Appeal Decision

Appeal Ref: APP/R5510/W/24/3357807

Land adjacent to 19 Princes Park Close, Hayes, Middlesex UB3 1LB

- The appeal is made under section 78 of the Town and Country Planning Act 1990 (as amended) against a refusal to grant planning permission.
- The appeal is made by Mr Jaswant Kooner against the decision of the Council of the London Borough of Hillingdon.
- The application Ref is 75586/APP/2024/1225.
- The development proposed is construction of a four-bedroom detached house.

FRONT ELEVATION

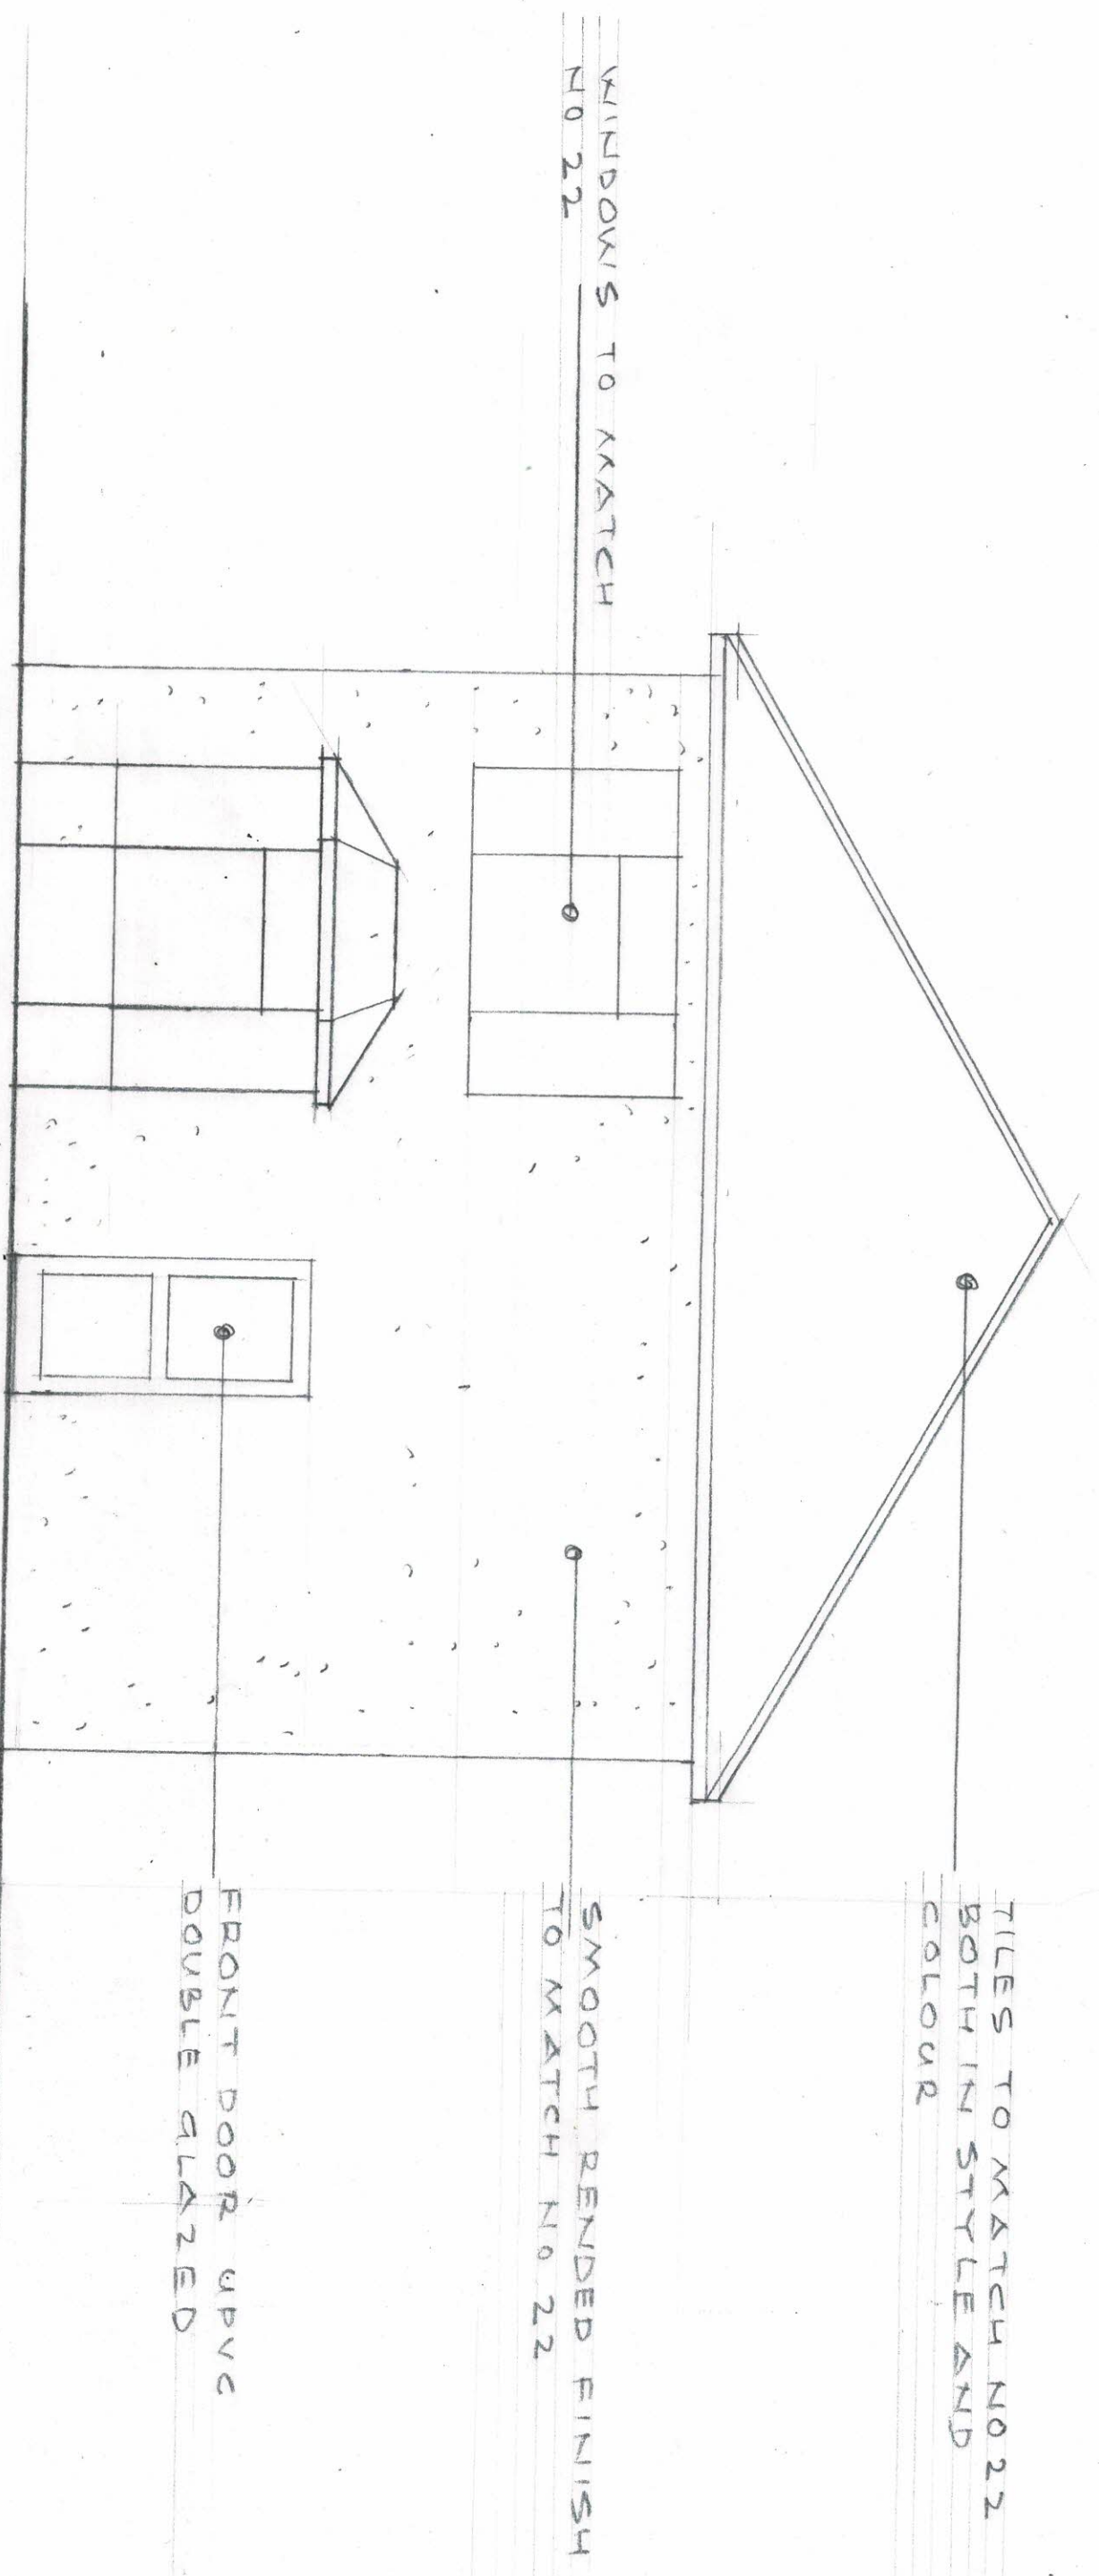
of the road, be visible from all along the Close. It would be sited further back from the road than any of its neighbours and be wider than them. Whereas other homes nearby have windows on both sides of their front elevations, the proposed house would only have them on the left-hand side.

7. In the absence of a counterbalancing development on the opposite side of the Close, the proposed house would significantly and harmfully undermine its existing symmetry and balance. This would be exacerbated by the house being sited in noncompliance with established building lines, by it being the only detached house in the Close, by its locally unique and strikingly unbalanced fenestration arrangement, and by its uncommonly expansive paved forecourt. Each of these would be incongruous in the homogeneous setting, emphasising the presence of the dwelling in the Close.

SCALE 1:200 DATE APR, 24
2023/11/107/A

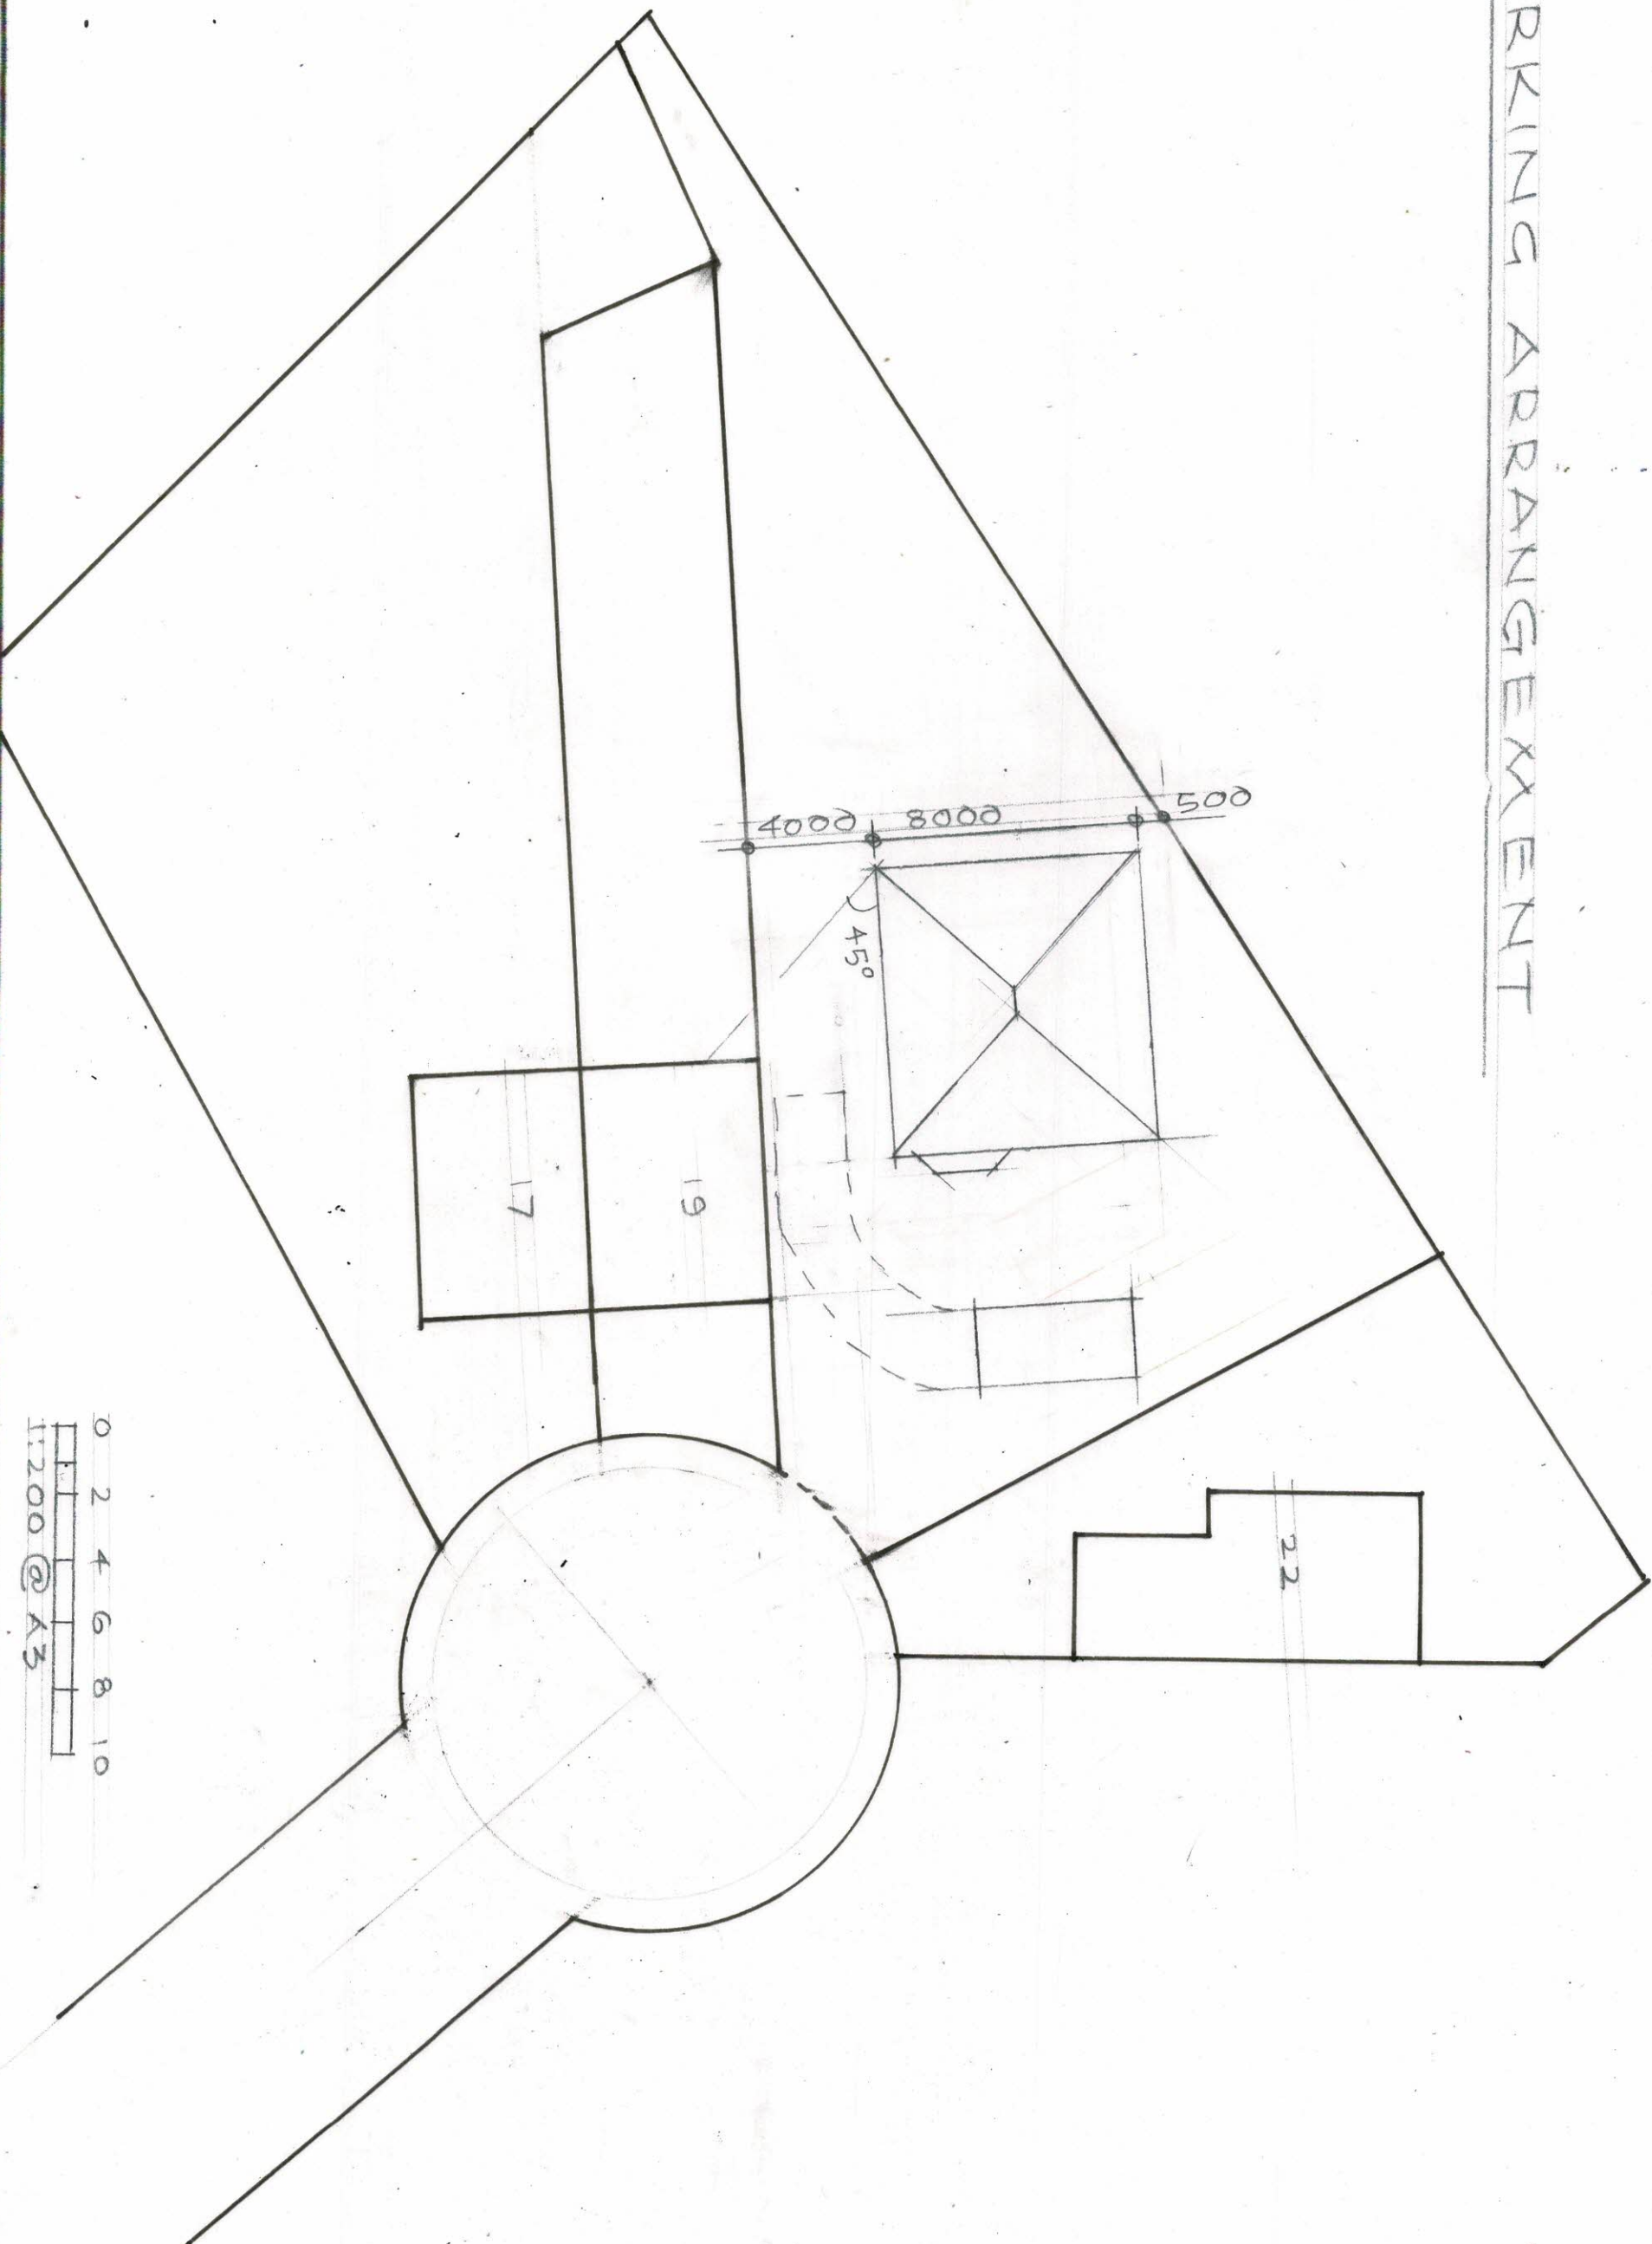
6. The proposed development is a detached house, set beyond No 19 at the furthest point of the Close. It would, as a consequence of its position relative to the centre

8. Furthermore, in eroding the exiting gap, the development would damage the current open, spacious feel at the far end of the Close, introducing a cramped, congested feel in its place.
